Engineers comments in respect to surface water drainage and land drainage below. Please note these comments also relate to relevant conditions on F/6/20/DOC, but since they are all related, the comments have been amalgamated together.

Subject: Planning Consultation on F/9/20/DOC

Site Address: Wicks Farm Ford Lane Ford BN18 0DF

Description of Works: Approval of details reserved by condition imposed under ref F/30/18/PL relating to Condition No 3 - surface water drainage.

TYPICAL SECTION SHOWING SWALE 1 PROFILE

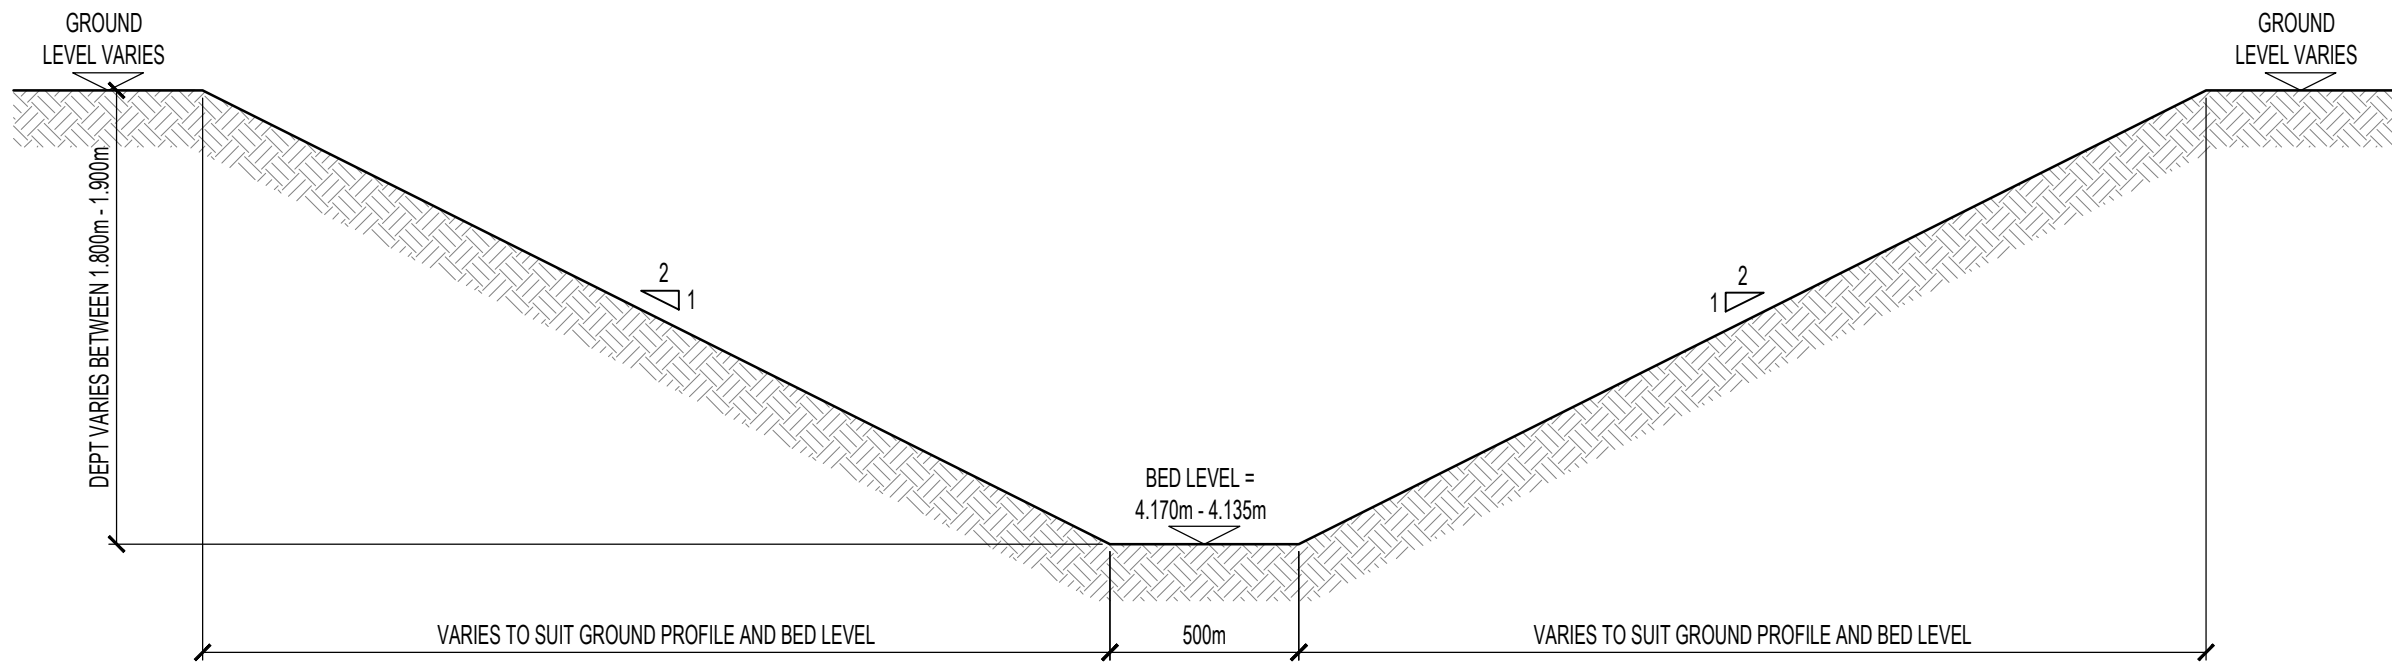
14. Swale connection to the new northern ditch – angle the point of entry to ensure flows merge in an improved manner.
15. Provide fully detailed insitu headwall construction details, for links between pond 1 and swale, and between swale 1 and 2.

21. Outlets to swale 1 – provide min. 100mm freeboard between swale bed and pipe inverts.
22. Provide positive fall on pond 1 (swale) bed.
23. All pipes to connect soffit to soffit unless otherwise specified – add note.

TYPICAL SECTION SHOWING SWALE 2 PROFILE

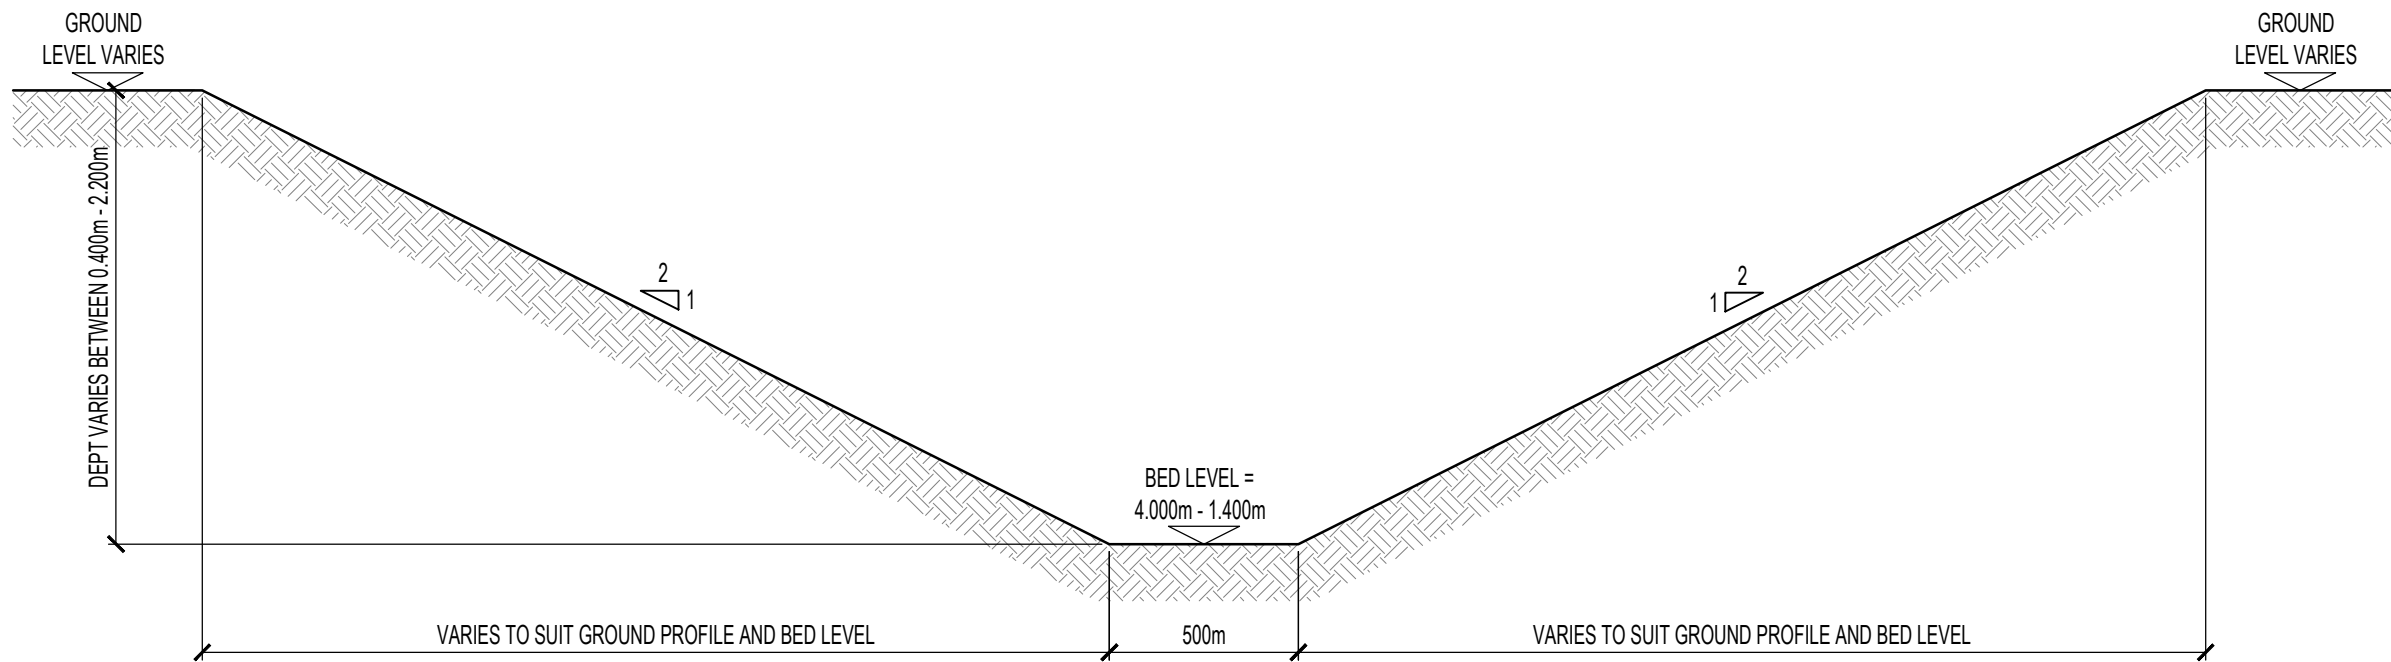
16. Incoming 225mm pipe to swale 2 – provide min. 100mm freeboard between swale bed and pipe invert.
17. Pipe concrete bed and surround detail – specify the specific concrete mix on the detail itself.

TYPICAL SECTION SHOWING POND 1 PROFILE

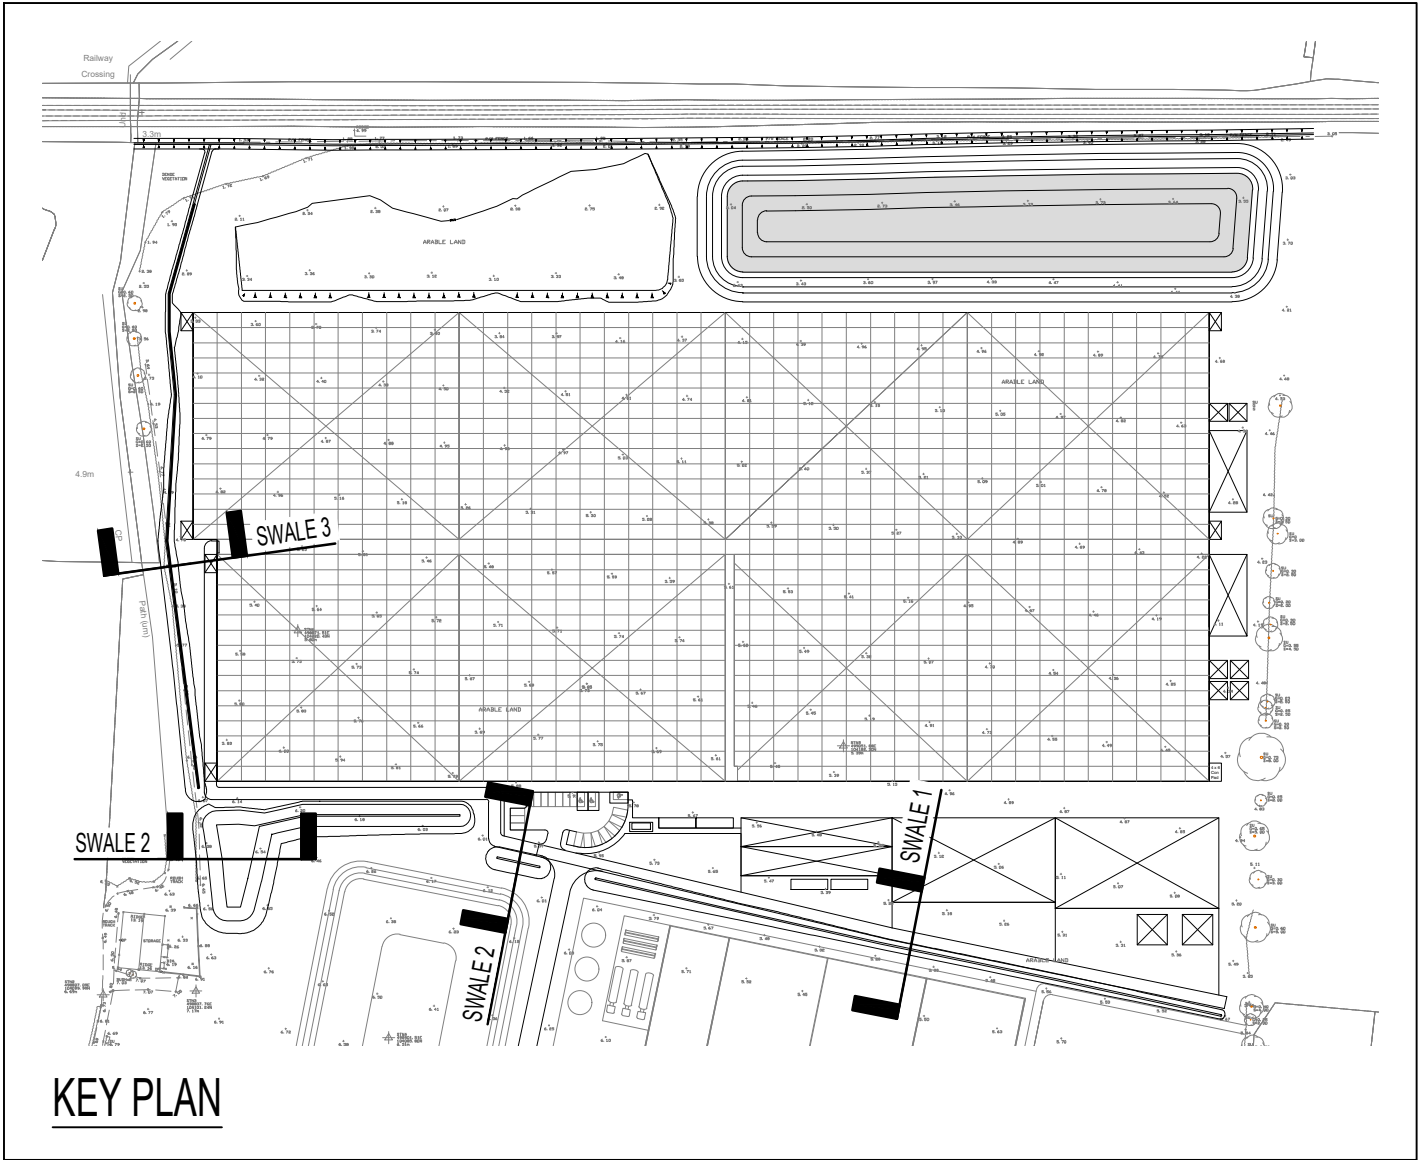
26. Pond 1 and associated swales – show top of bank levels on all sides.
27. Provide causeway flow calculations for reservoir system. The CEP calculations provided were only preliminary and do not reflect the actual design.

PRIVATE MANHOLE DETAIL TYPE W (WITH CATCHPIT)
DEPTH FROM COVER LEVEL TO SOFFIT OF PIPE 1.0m - 1.5m
INTERNAL CHAMBER DIAMETER 1500mm*
MAX. SEWER DIAMETER 375mm
(SCALE 1:25)

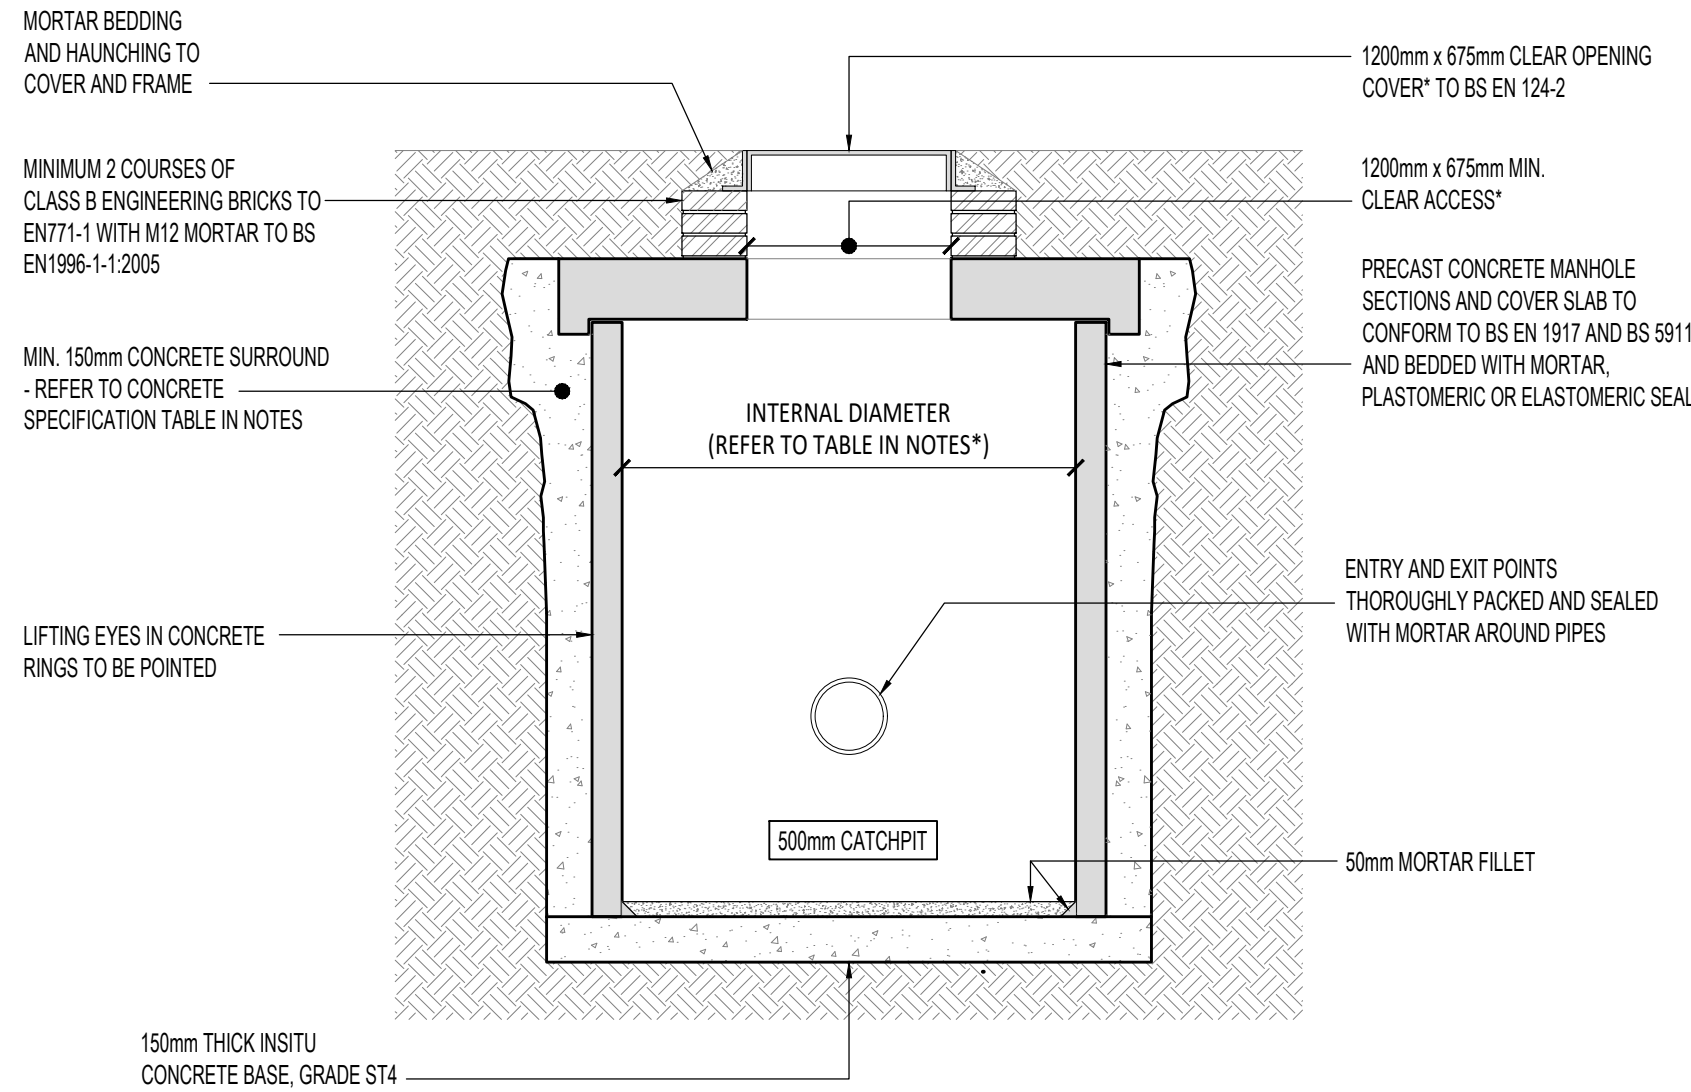
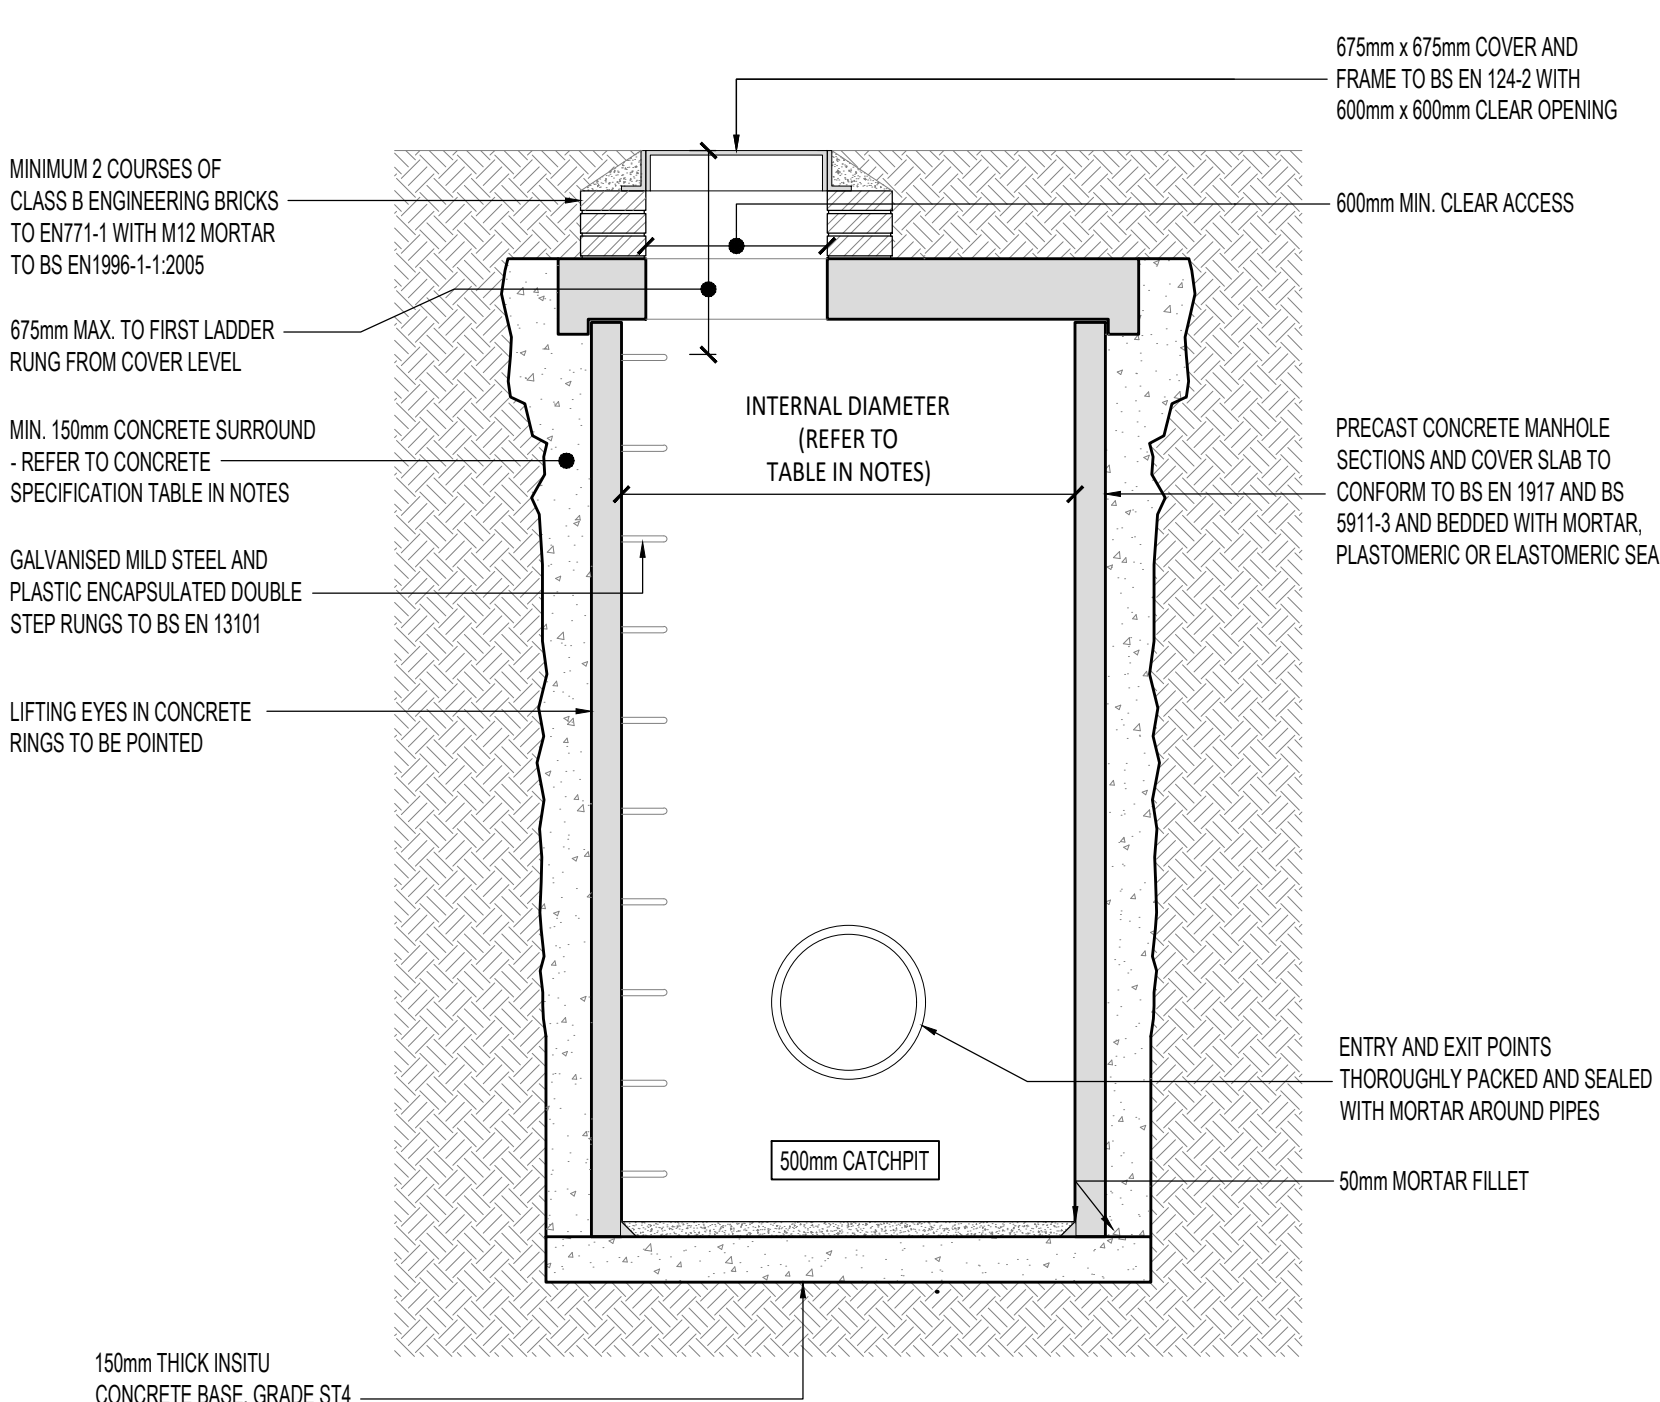
12. Catchpit type W detail – include step rungs for access.
13. Reservoir outlet is at very steep gradient and connecting at 90 degrees to the hydrobrake. Resultant flows could affect the performance of the hydrobrake – could this arrangement be revised to improve the situation.
